Variation of condition 15 imposed under EG/29/13/ relating to condition 15 - to change the foul drainage scheme from Sewage Treatment Plant to Pumping Station with associated drainage works.

Former Brooks Nursery Eastergate

Thank you for your internet representation made on 21st March 2020 which has been recorded as '**an objection**' with the comments as follows:

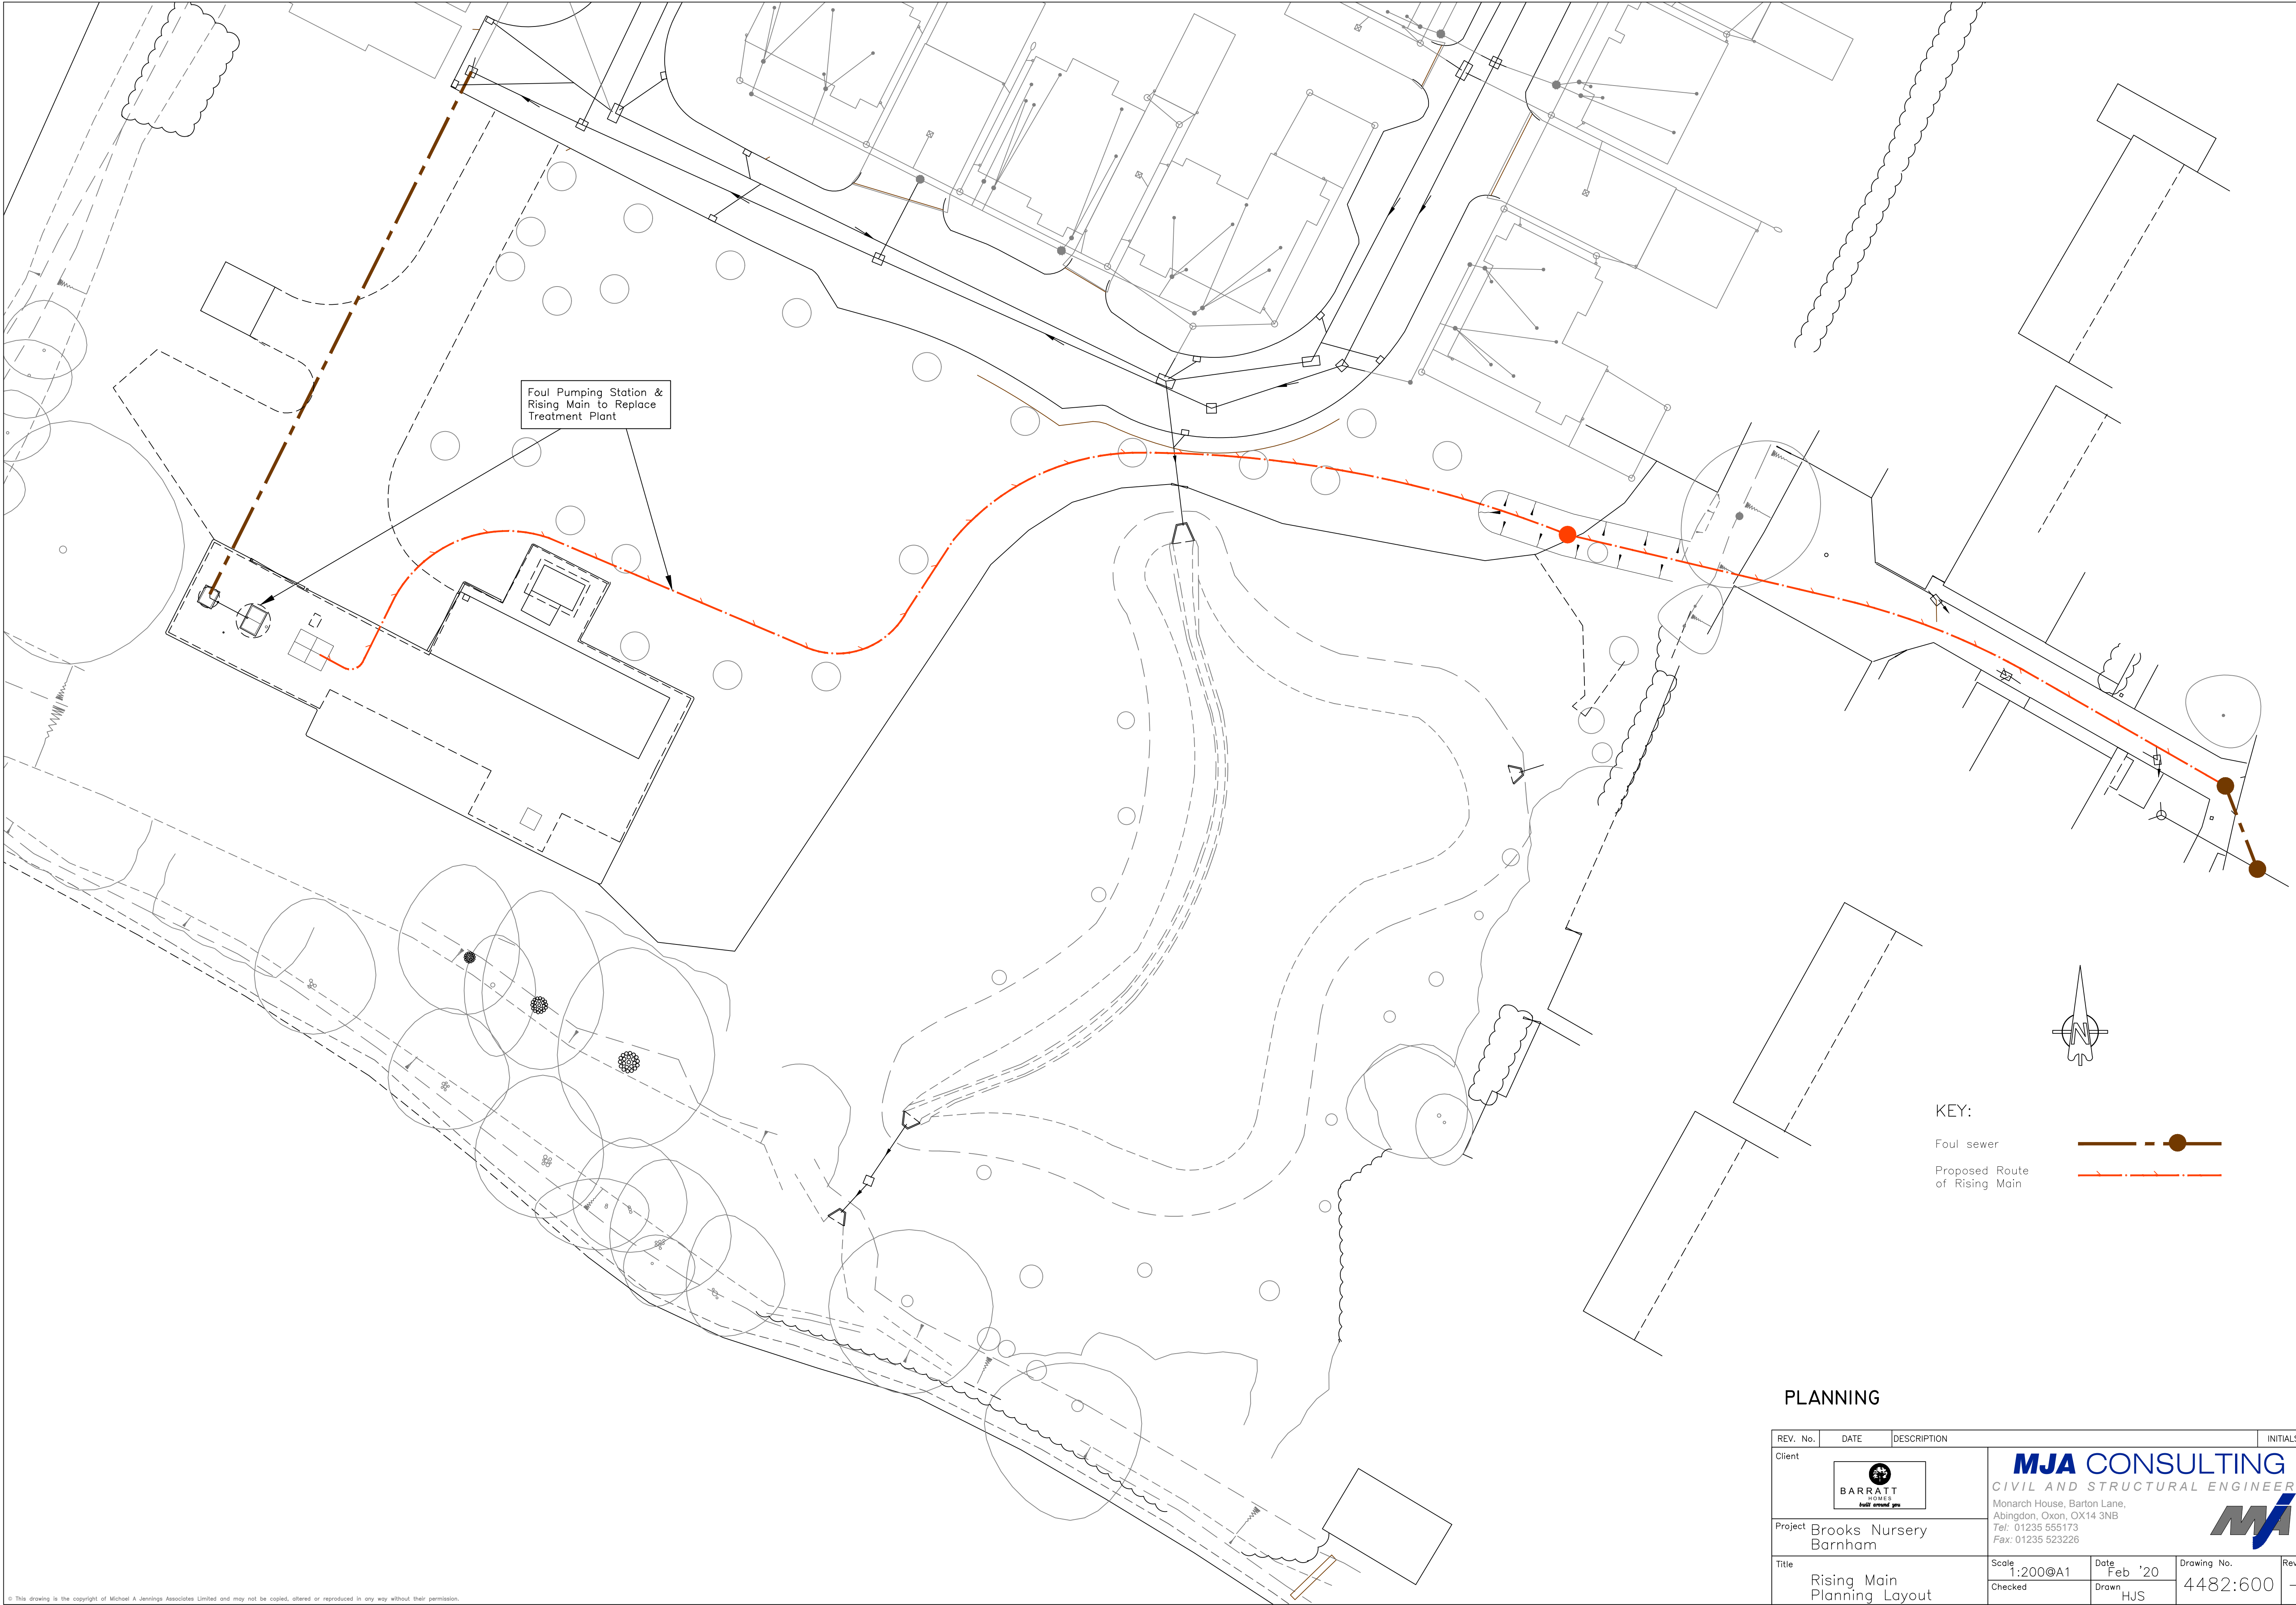
-
- 1. *The plans do not highlight the pipes in Elm Grove South where they go how they are routed.*
- 2. *The diagram 43390d4f6ffb403.pdf has an added "treatment works" area which seems to be an after thought and not properly planned. Google maps street view image 2016 has a treatment works which seems to have the treatments works in place.*

- 3. *I have been told that the new rising main will be 8" plastic pipe and this is going to replace the original treatment plant. No reasoning for not using the original treatment plant has been given.*

- 4. *Why are they not connecting into the main sewer system in Barnham Road?*
- 5. *The fact that an 8" plastic pipe going into a 6" Gravity fed clay pipe sounds like a cheap bodge job and the houses have been built and are now occupied, should have been planned properly in the first place. I think they should pay to renew our Elm Grove South sewer system. See point 4*

- 6. *The pressure from the 8" pipe is unknown how do we know if a blockage in the 56 year old clay pipe anywhere along the unknown clay pipe system would.*
